Tel: 01903 737756
Email: planning@arun.gov.uk
www.arun.gov.uk/planning
Please ask for: Breezie Allwright
Email: breezie.allwright@arun.gov.uk
Telephone: 01903 737500
Our Ref: AB/114/25/T
Your Ref:
Date: 10th September 2025

Application for Works to Trees(s) subject to a Tree Preservation Order(TPO)

Development: 1 No. Macrocarpa (T1) removal of deadwood greater than 25mm and crown lift to a height of 4m. Crown lift to 1 No. Holly and 1 No. Bay to a height of 4m and fell 1 No. Elder (G2). Fell 1 No. dead Elaeagnus (T3).

Location: Martlets Court Queen Street Arundel BN18 9NZ

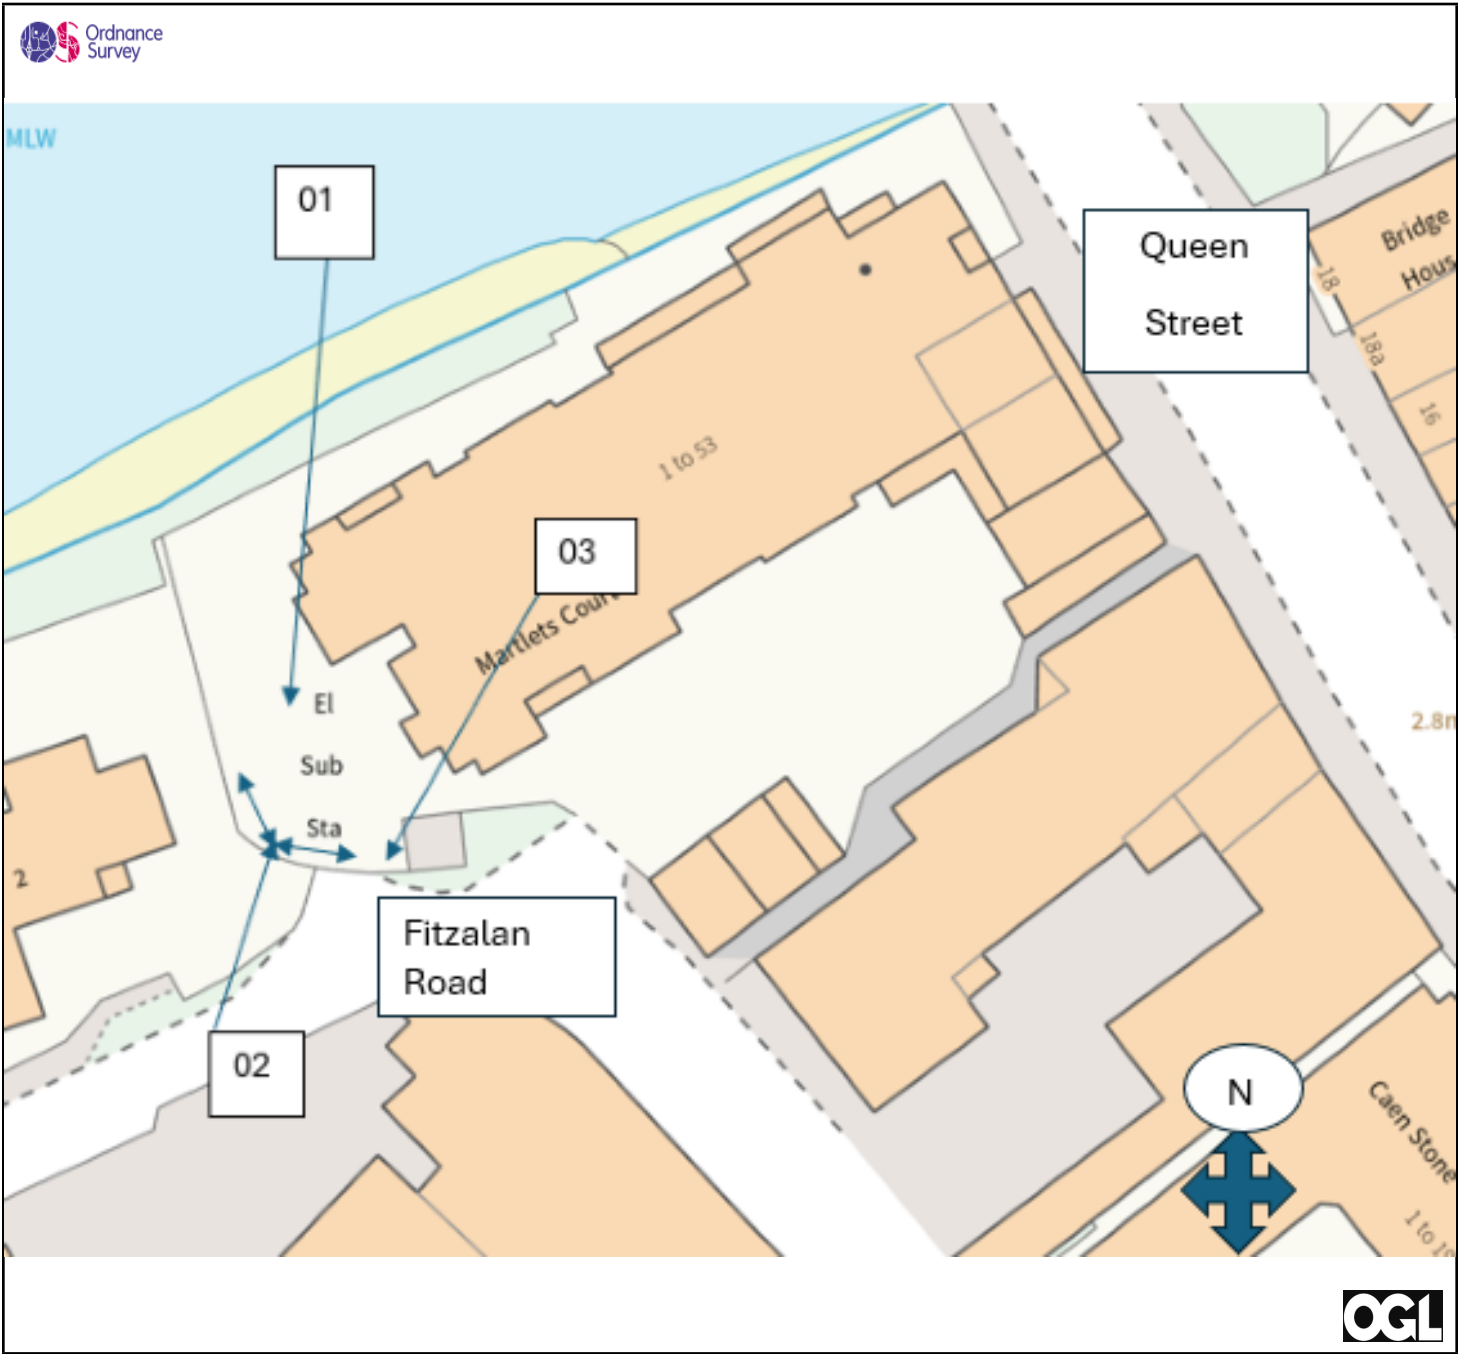
Please add a named road and North point to your sketch plan.
